From: Paul Cann
Sent: 20 November 2017 16:58
To: Planning.Responses
Subject: RE: Planning Consultation on: LY/25/17/PL

Engineers comments in respect to surface water drainage:

APPLICATION **LY/25/17/PL**

Site Address: Roseland The Causeway Arundel BN18 9JL

Job No.	Drg No.	Rev
9712	01	A
Drawn by	Date	
rw	18.10.17	
Checked by	Scale	
BRP	1:50 @ A1

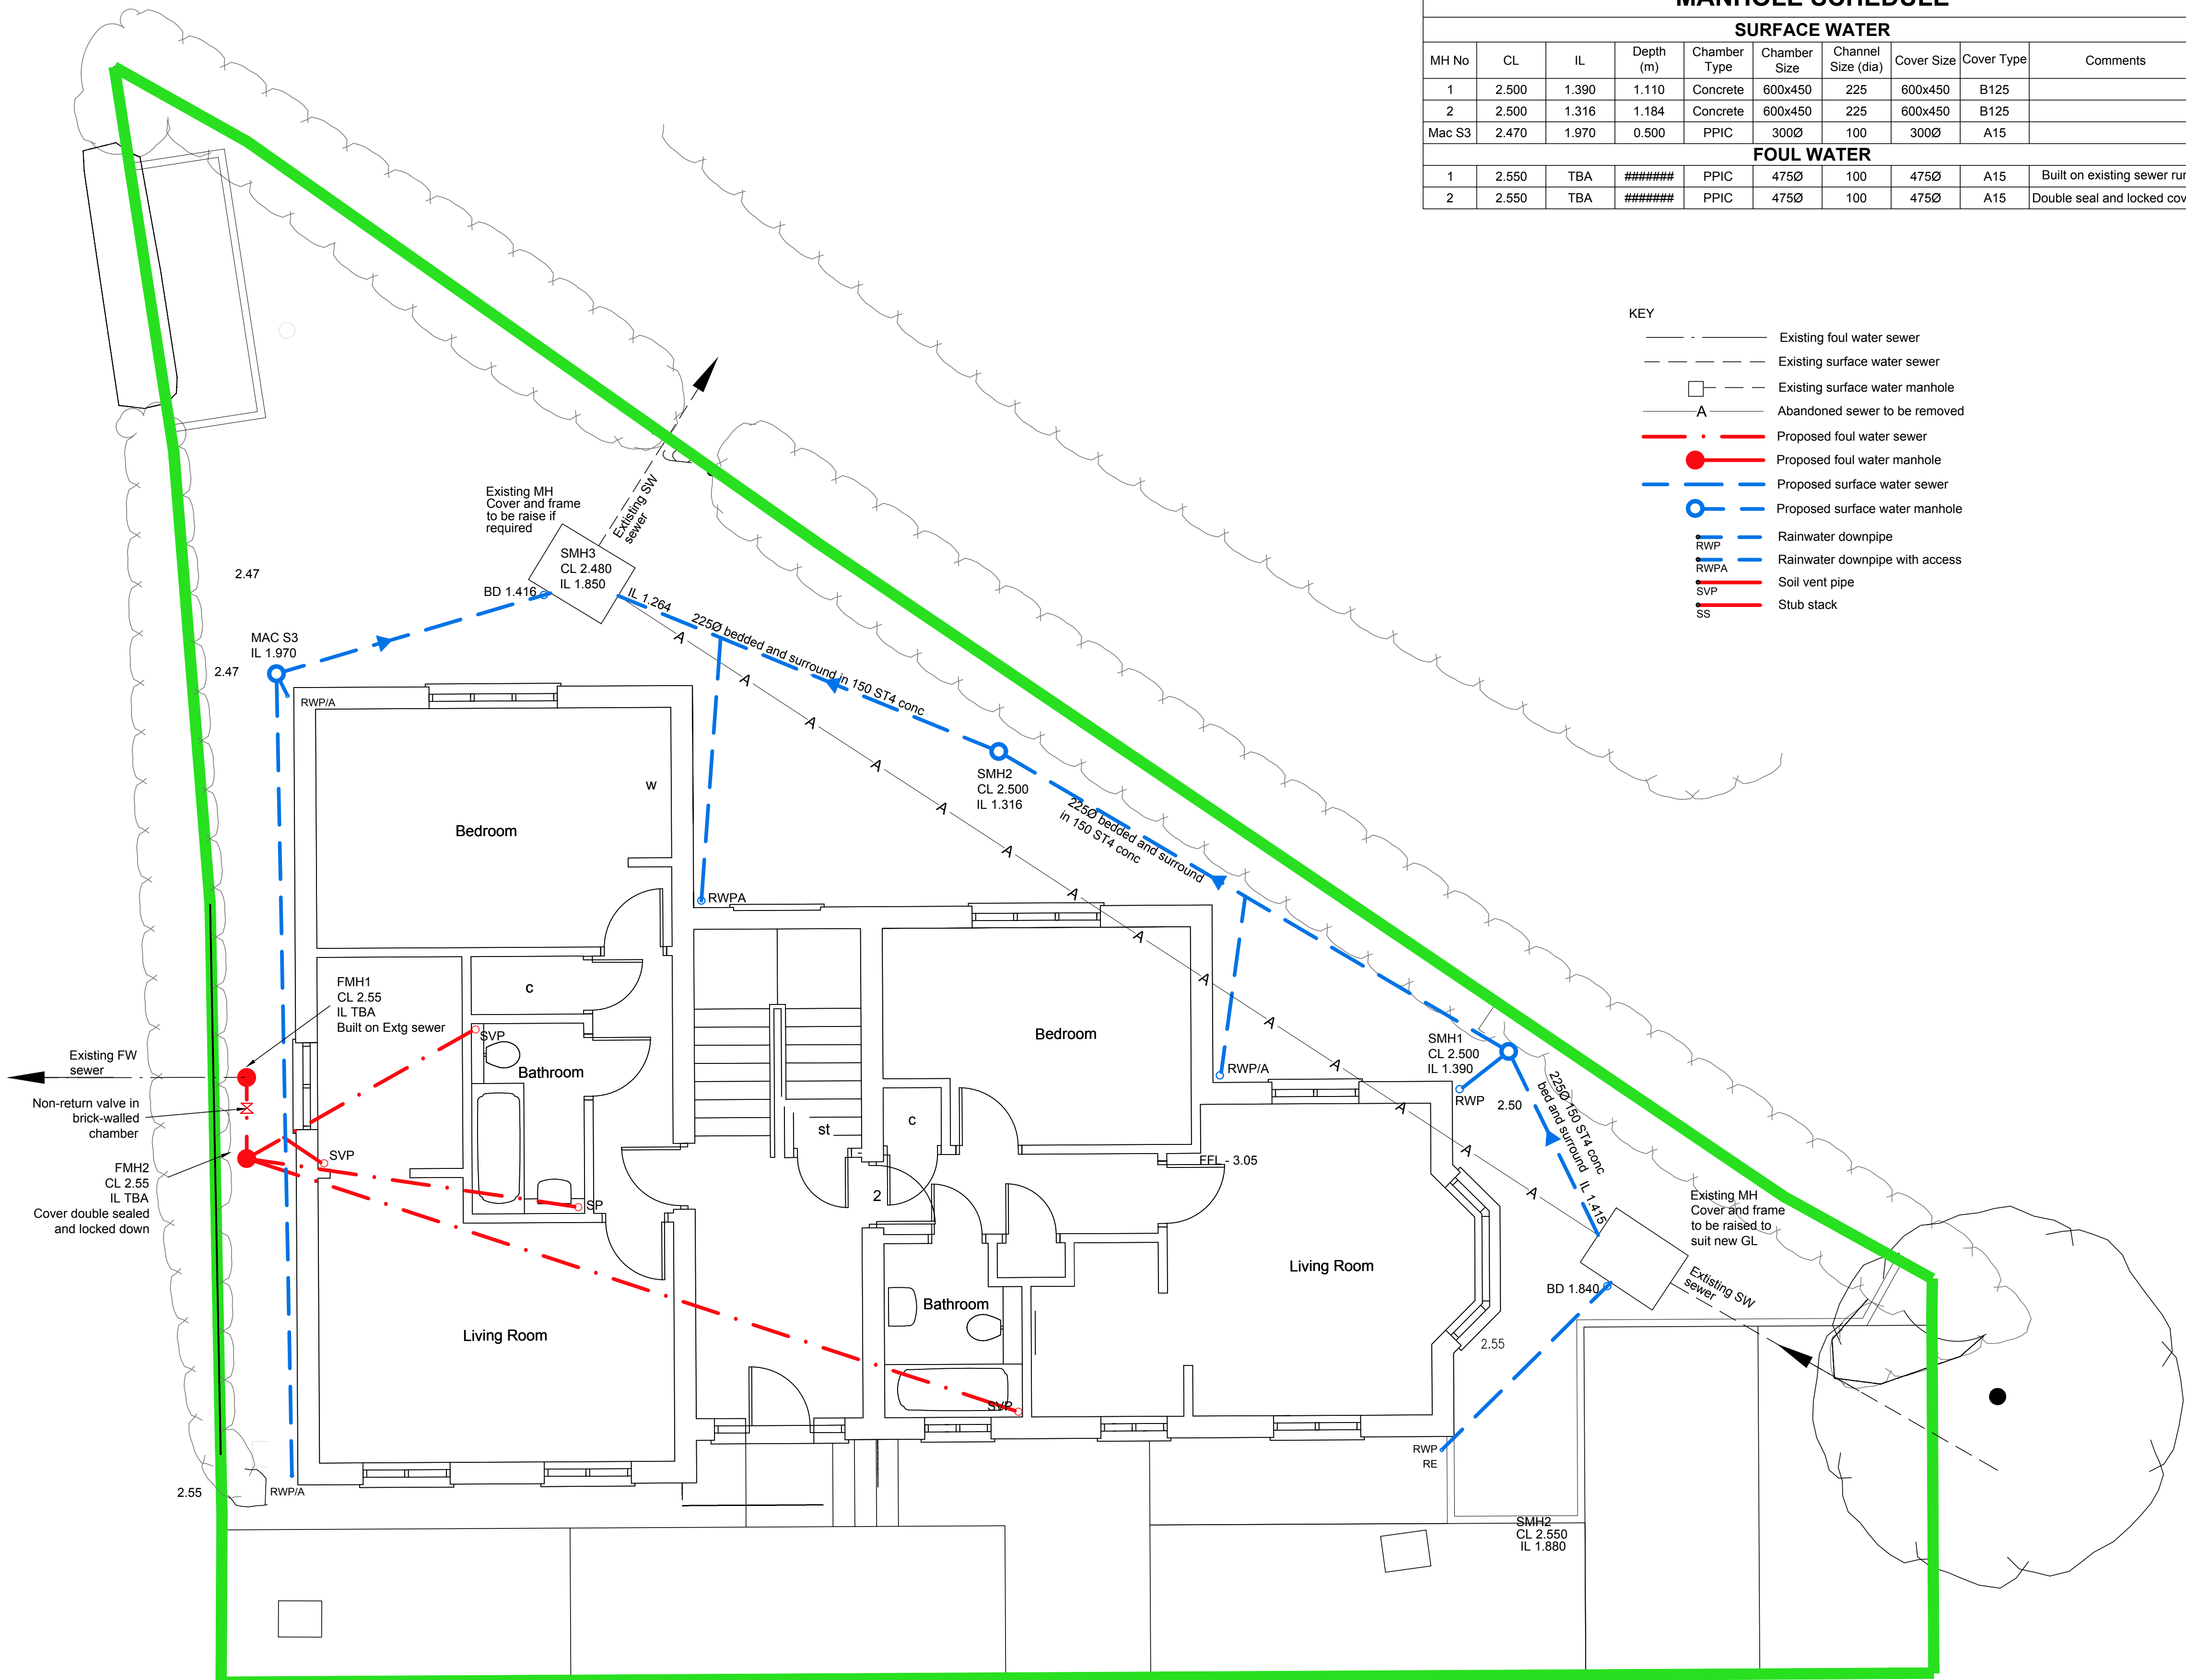
Please apply standard condition ENGD2A but modified to suit. As mentioned in the correspondence, we have agreed that soakage/infiltration is not possible on this site, so reference to BRE365/groundwater monitoring needs to be removed from the condition. The principle of what is shown on drawing 9712/01 Rev A is acceptable, ie. connections being made directly to the new/existing culvert. We just need to agree the finer details in this respect.

Please also apply conditions ENGD4A and ENGD6A. Whilst the principle of diverting the culvert is acceptable (as shown on drawing 9712/01 Rev A), again we need to agree the finer details.
